Recommendation Report for Planning Permission for Works or Extension to a Dwelling

REF NO: P/108/20/HH

LOCATION: 32 East Front Road
Pagham
PO21 4SU

PROPOSAL: Single storey rear extension including demolition of existing conservatory. 8 x rooflights and alterations to roof over front bedroom from gable to flat roof and conversion of central roof from hip to gable end with alteration to fenestration

Rev	Revision		Date
PROJECT			
32 East Front Road, Pagham			
TITLE			
Proposed Floor Plans			
DRAWING No. P0002		SCALE (@A1) 1 : 50	Project Ref: J20025

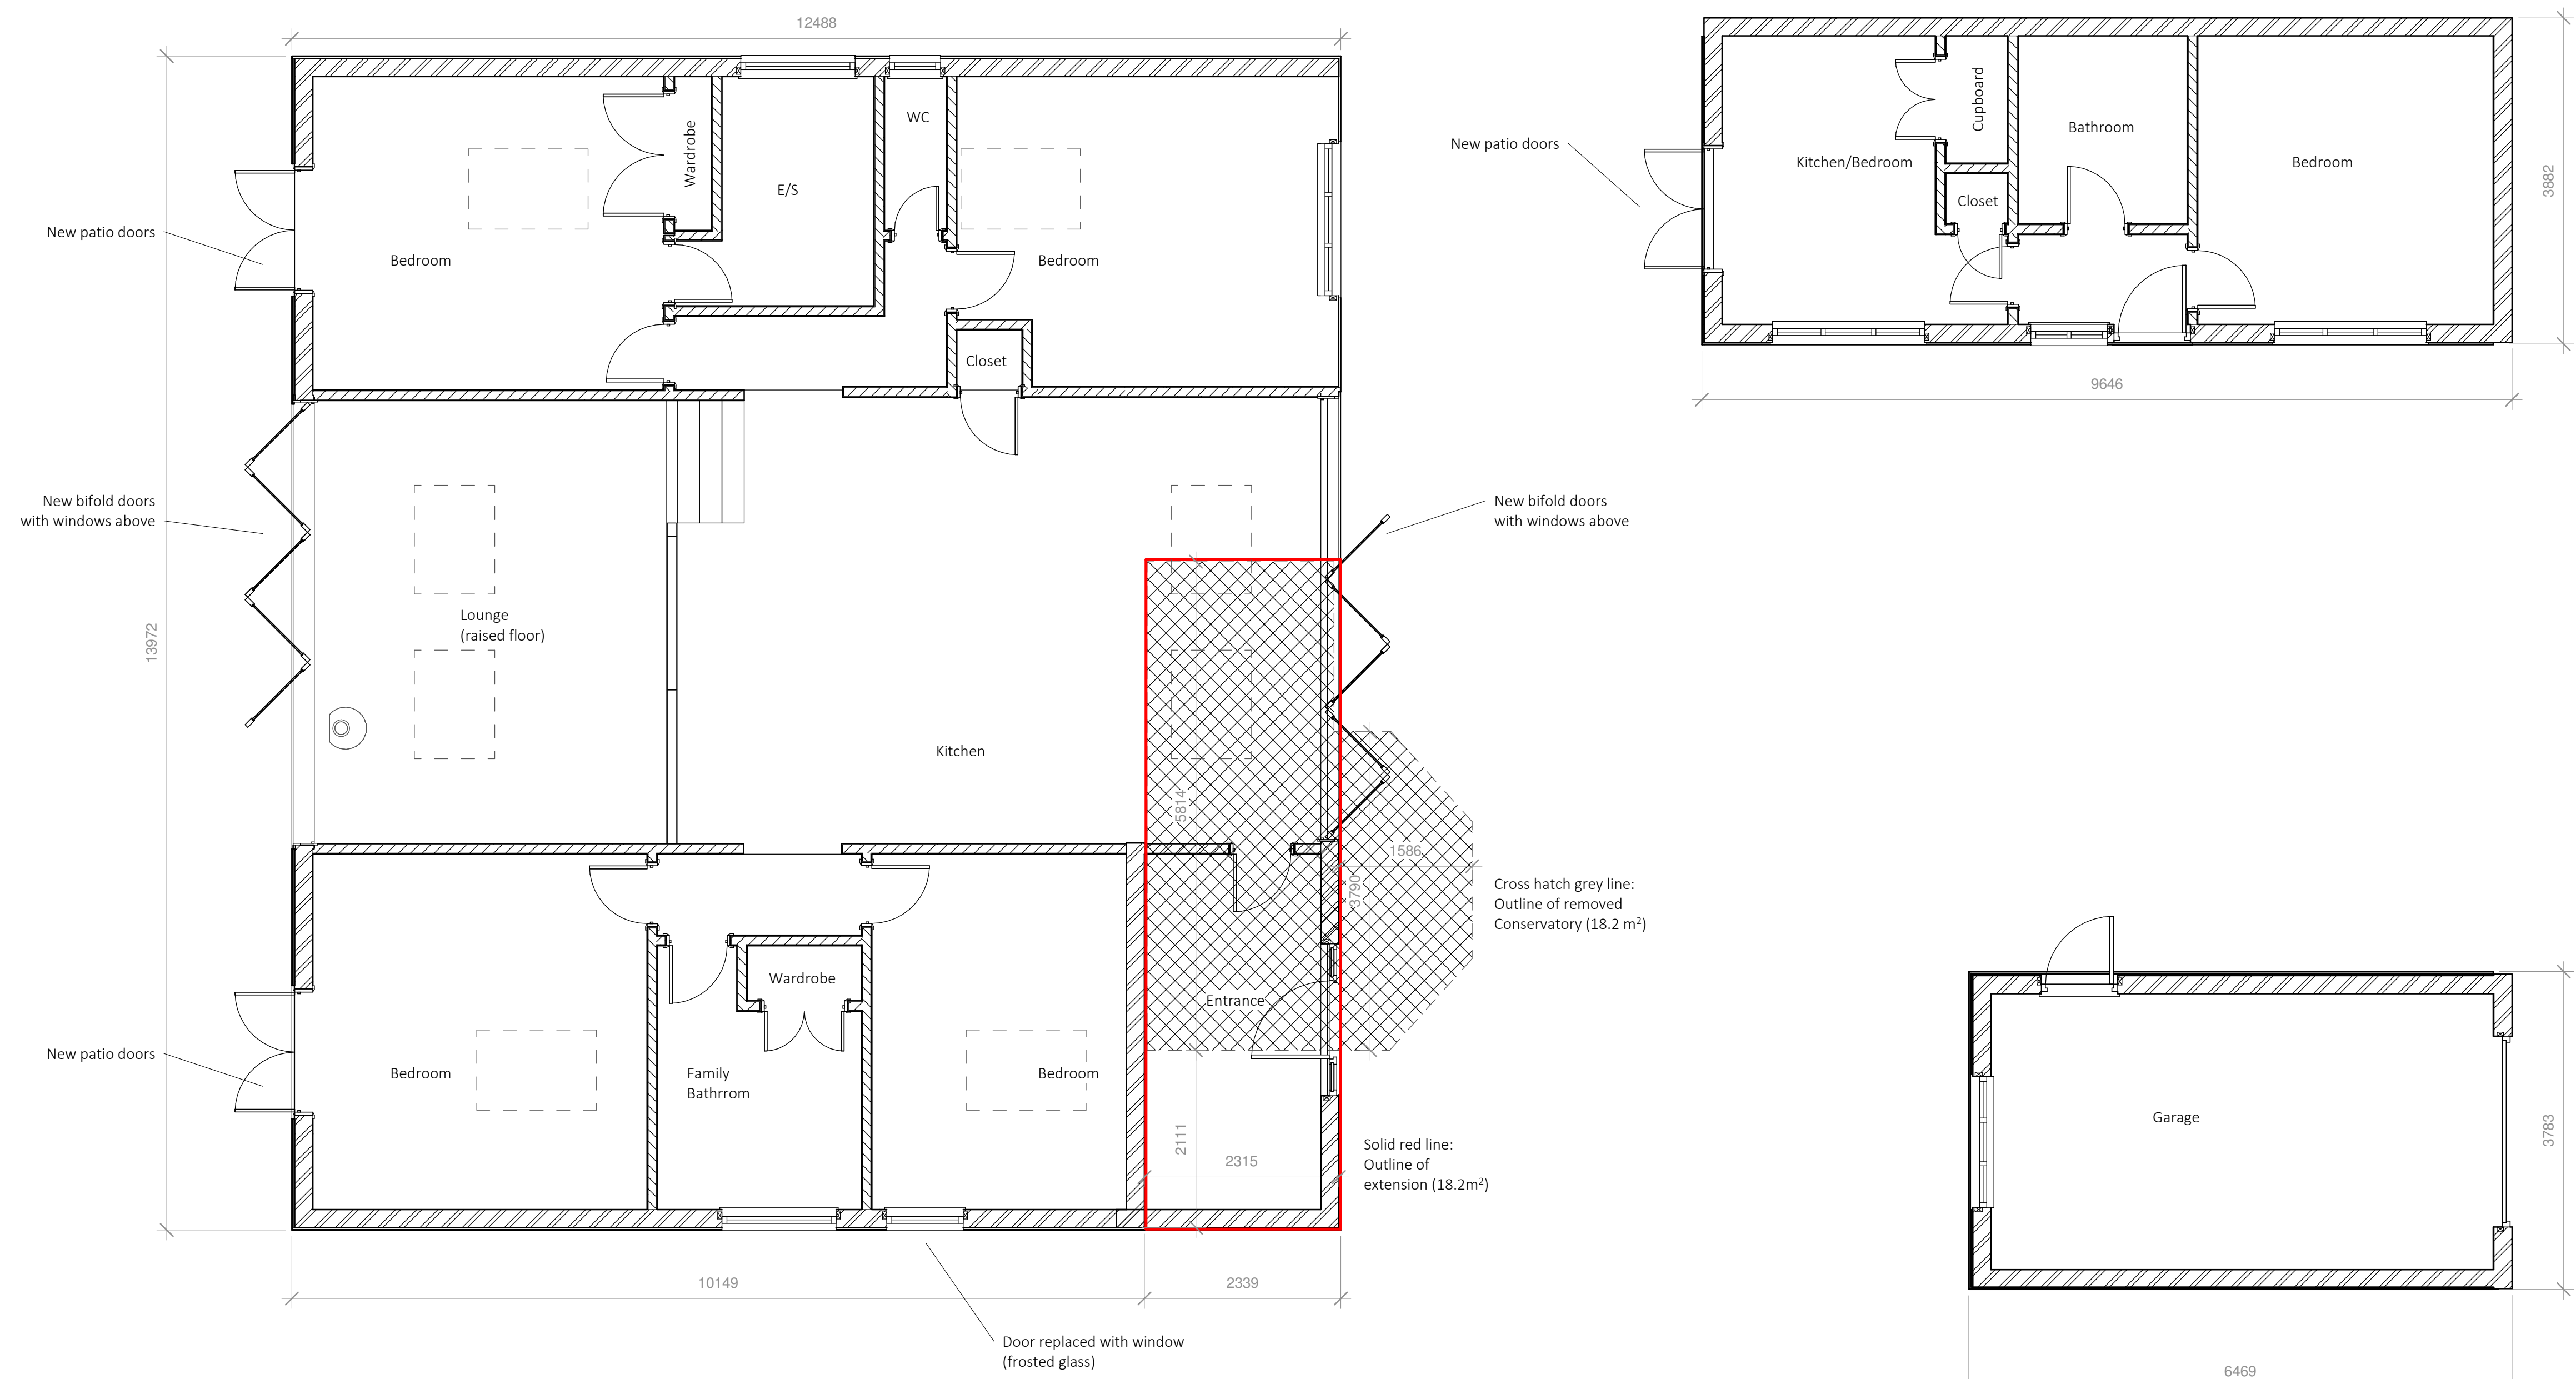
The property falls within Flood Zone 3 and is at a high risk of flooding. As such a Flood Risk Assessment was received. This follows EA standing advice for minor development and includes details relating to the height of floor levels. The Environment Agency did not respond to consultation.

Rev	Revision	Date
PROJECT		
32 East Front Road, Pagham		
TITLE		
Elevations - Proposed		
DRAWING No.	SCALE (@A1)	Project Ref:
P0006	1 : 100	J20025
THE EMARRA COMPANY		
www.emarra.co.uk Tel: 07803 924465 Email: info@emarra.co.uk

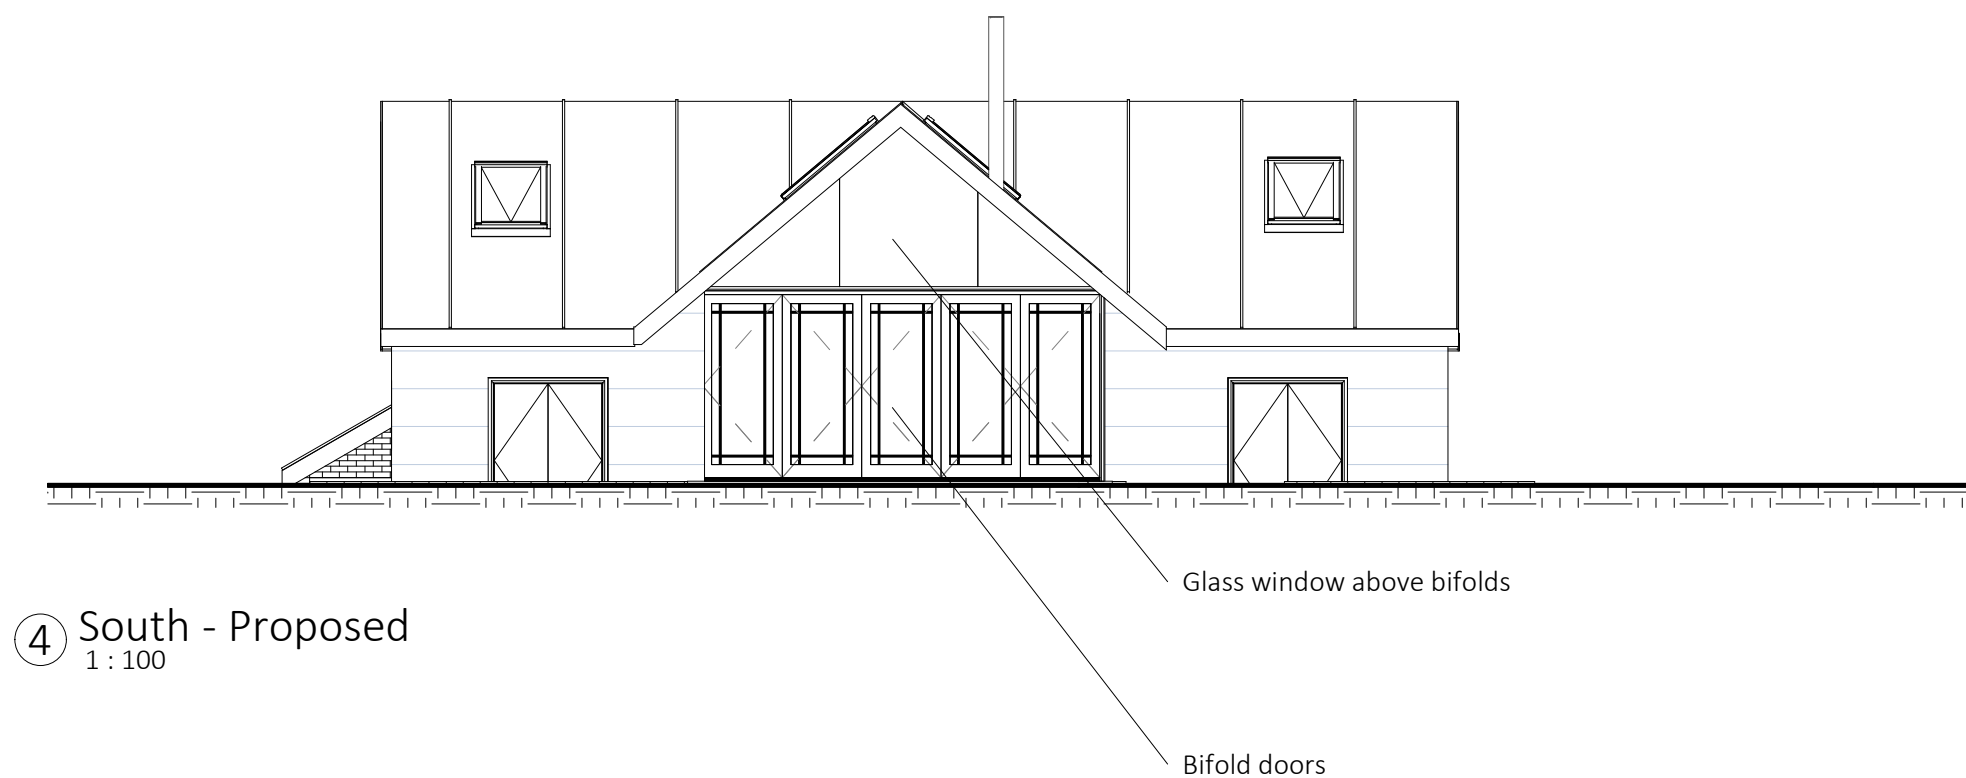
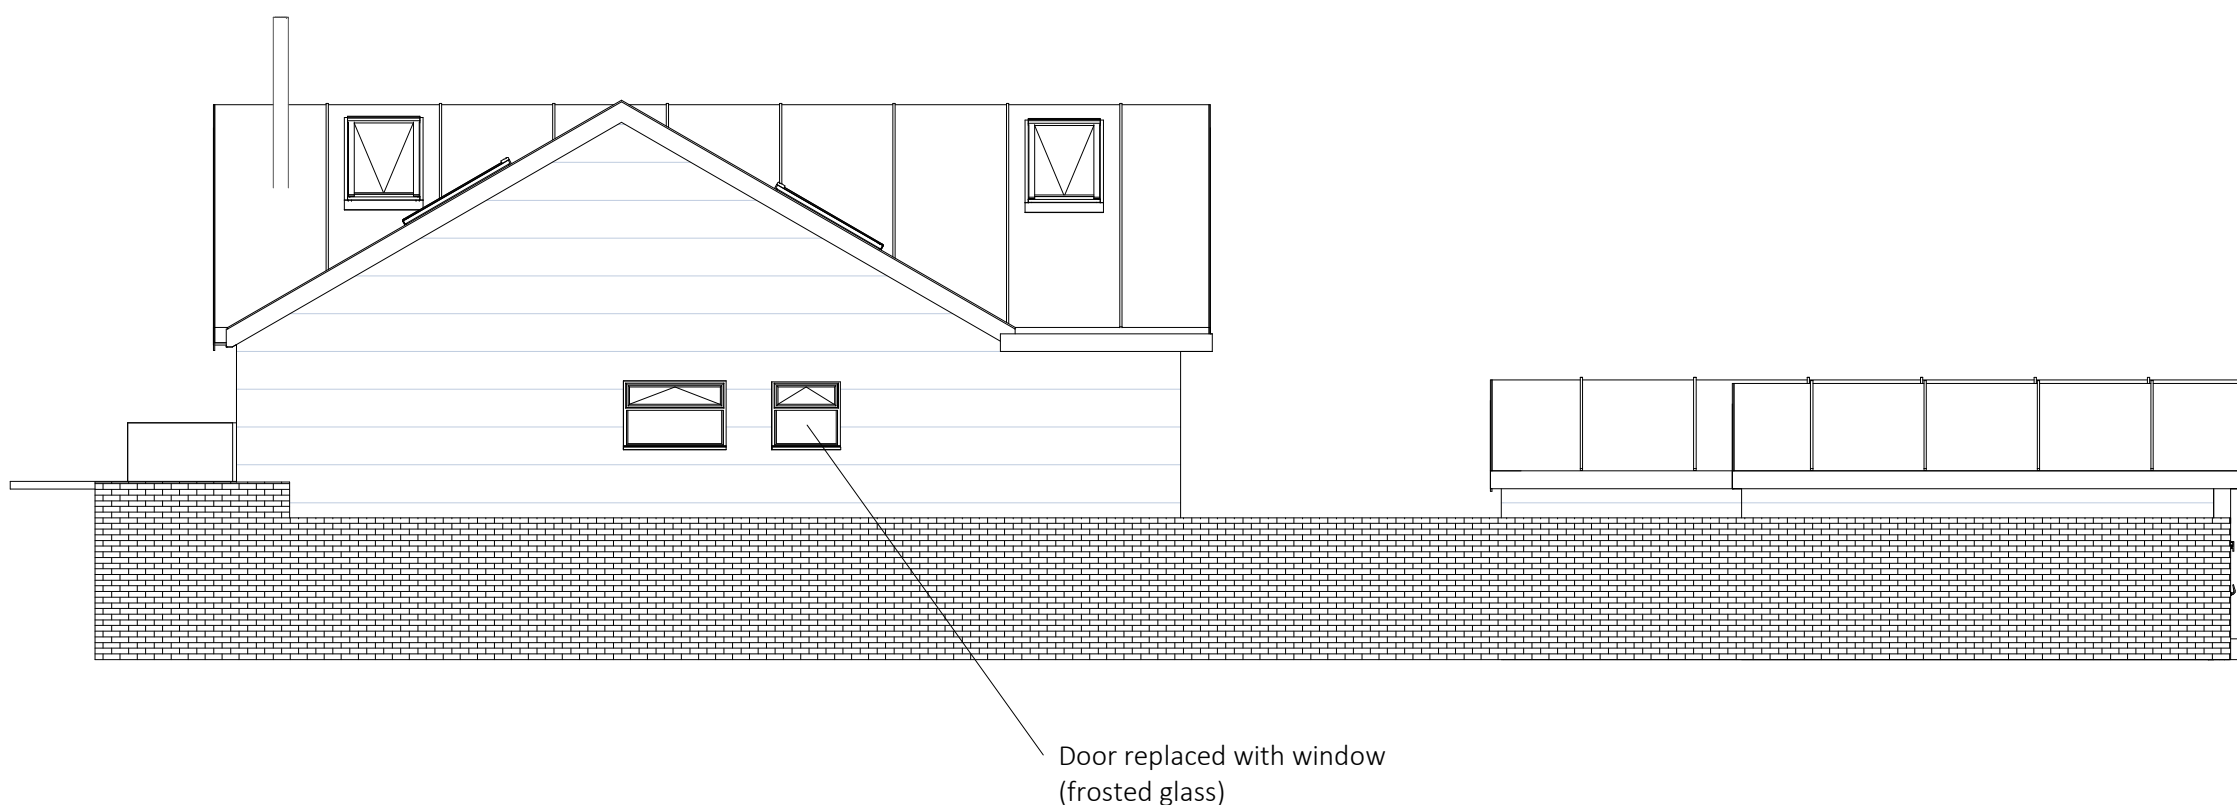
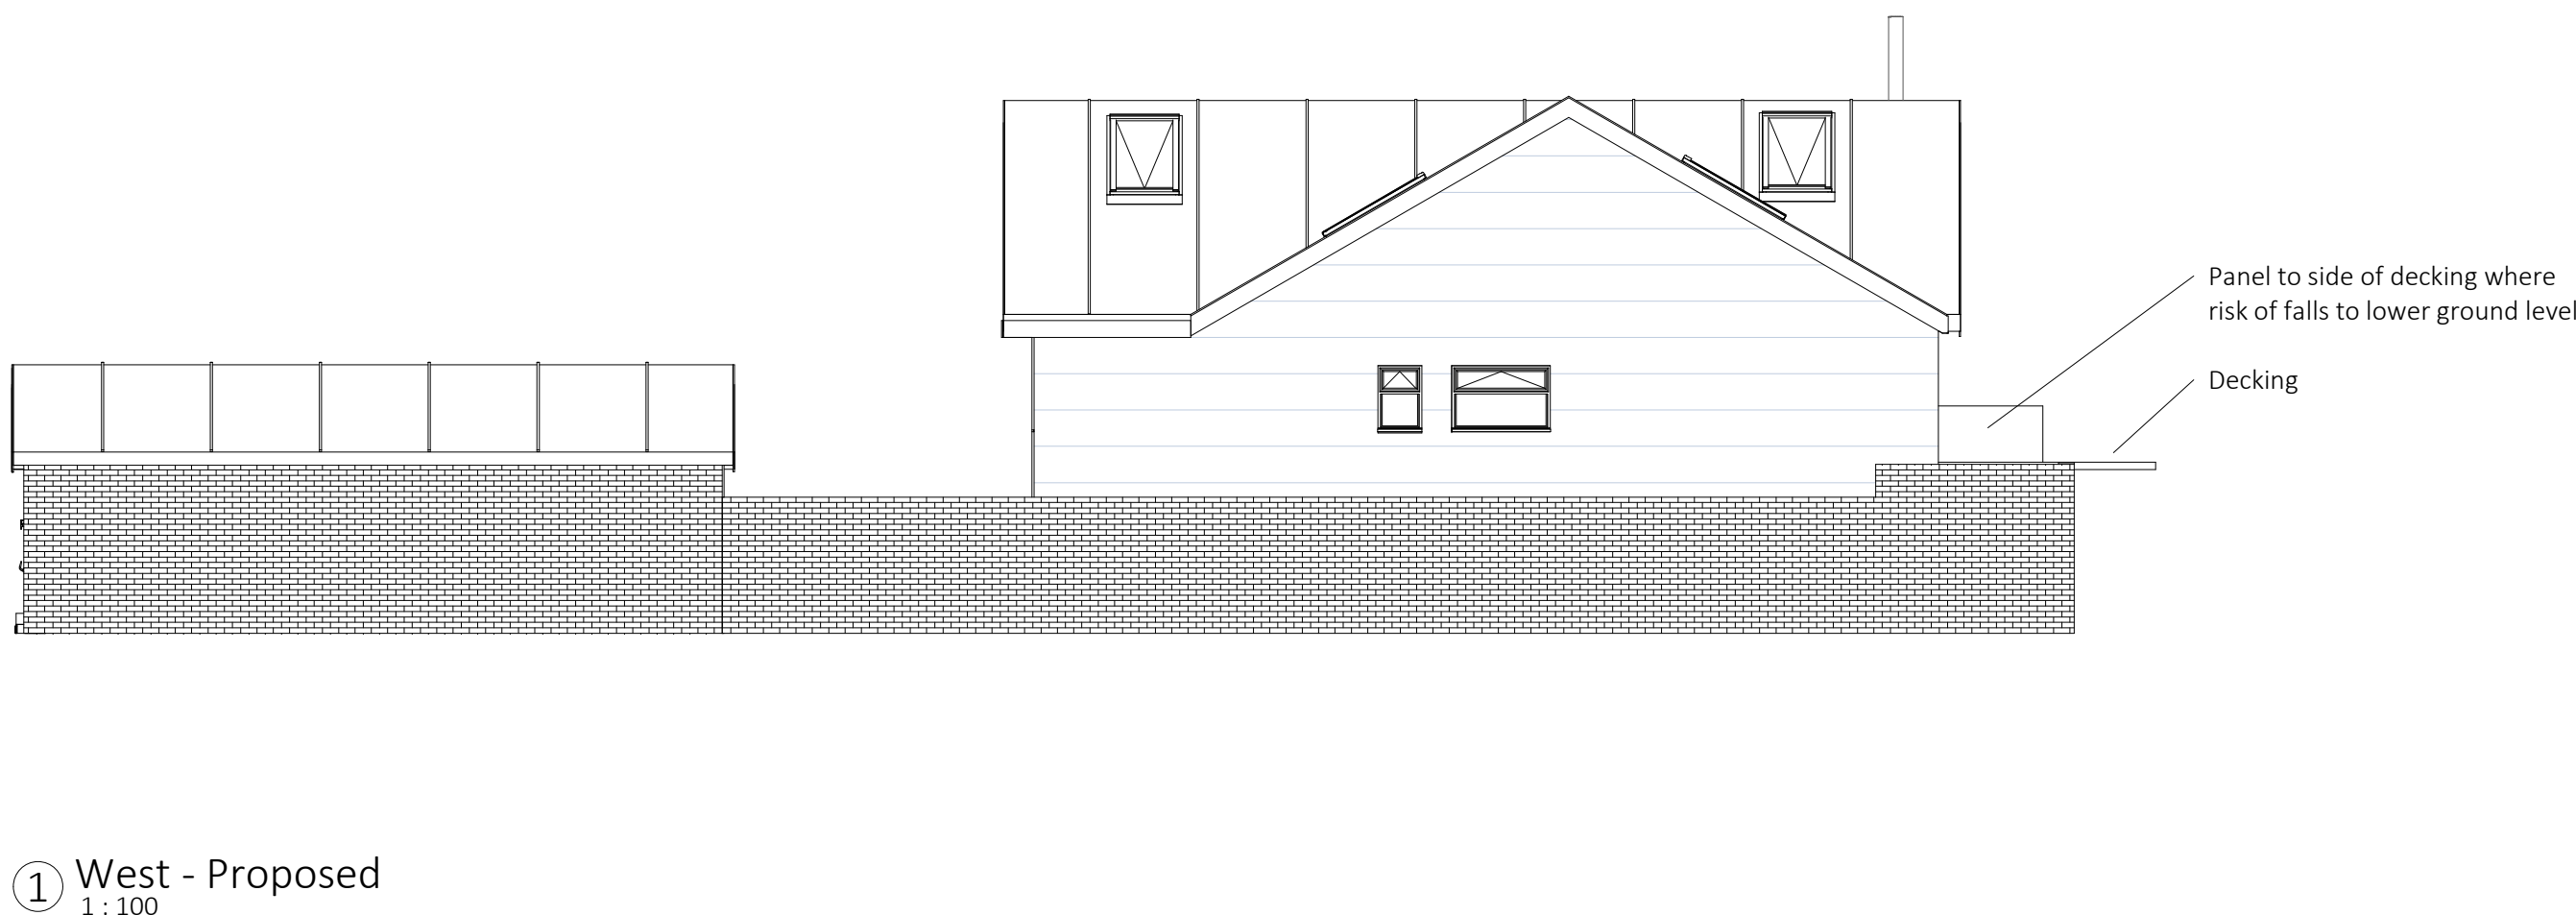
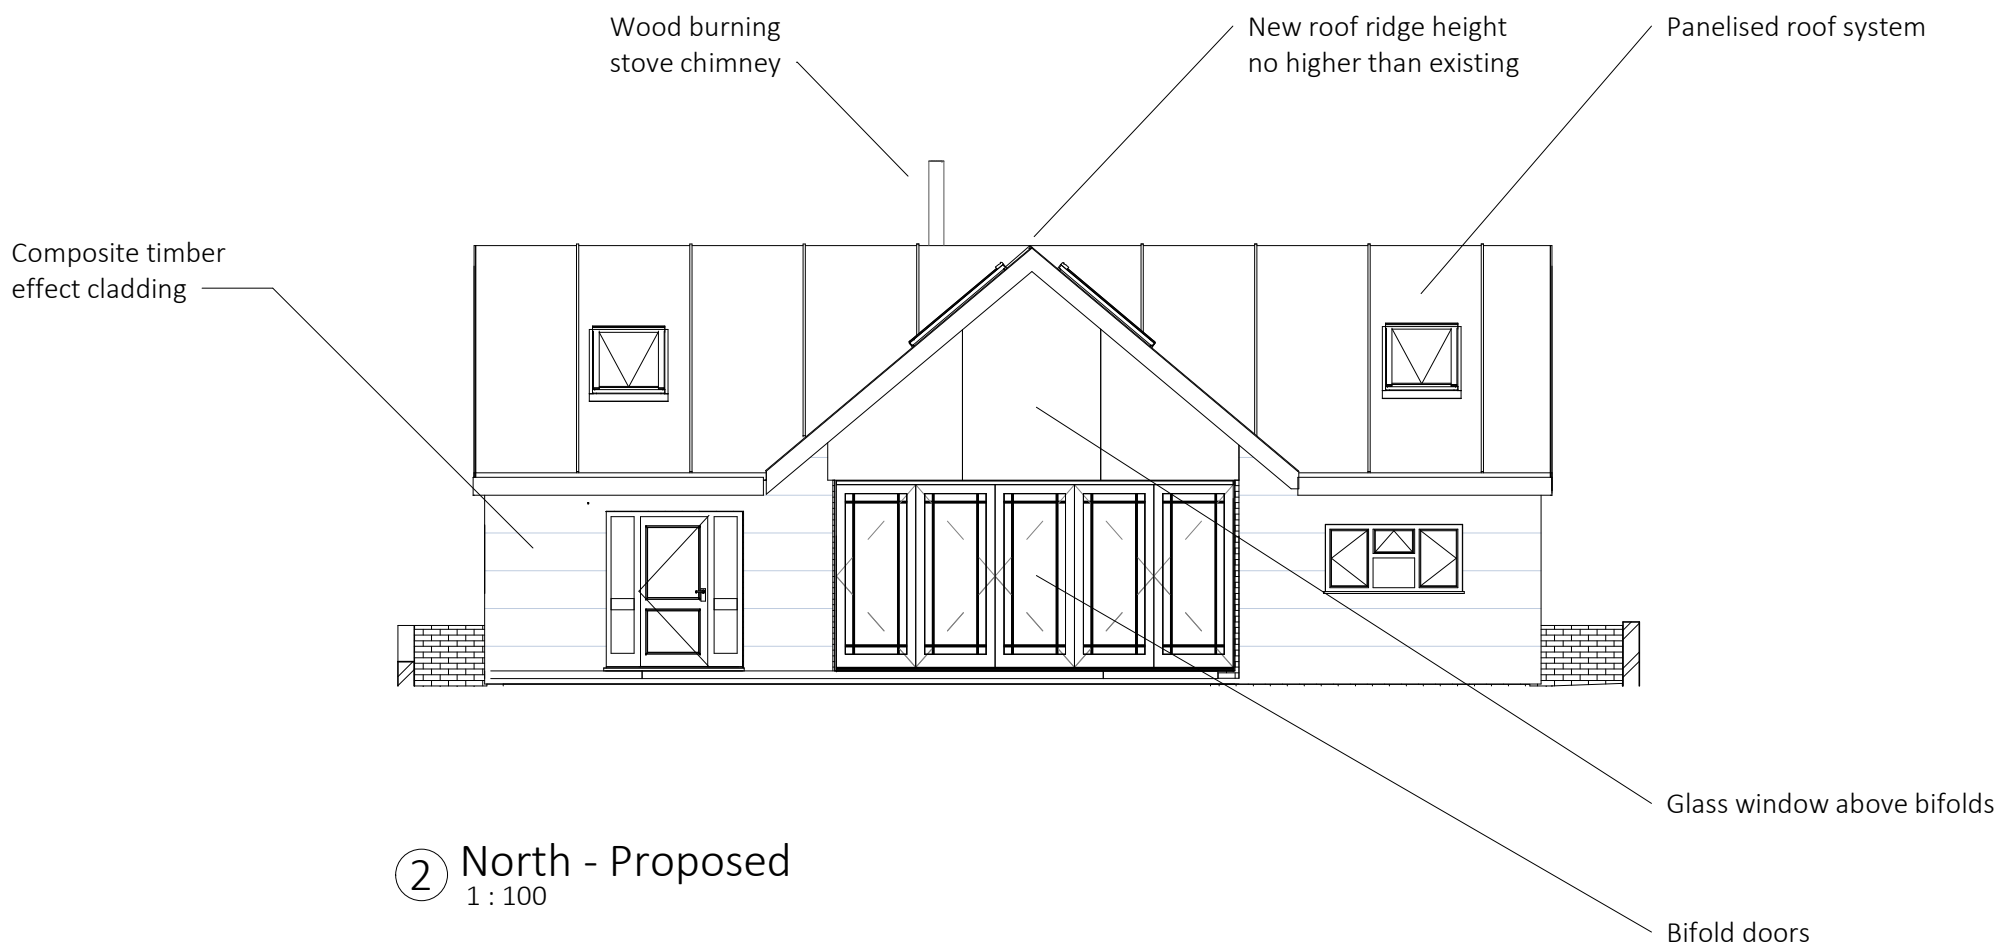
The northern elevation currently consist of a single storey extension and a conservatory and this will be removed and replaced with a gable roof extension. A gable pitch will also be constructed to the south to match that at the north.

The proposal will create a more uniform appearance to the northern elevation and it appears well integrated with the host dwelling.

The application also states that there will be cladding and an alternative roof material. No details have been received with regards to the colour of this and as such it will be conditioned for details to be submitted.
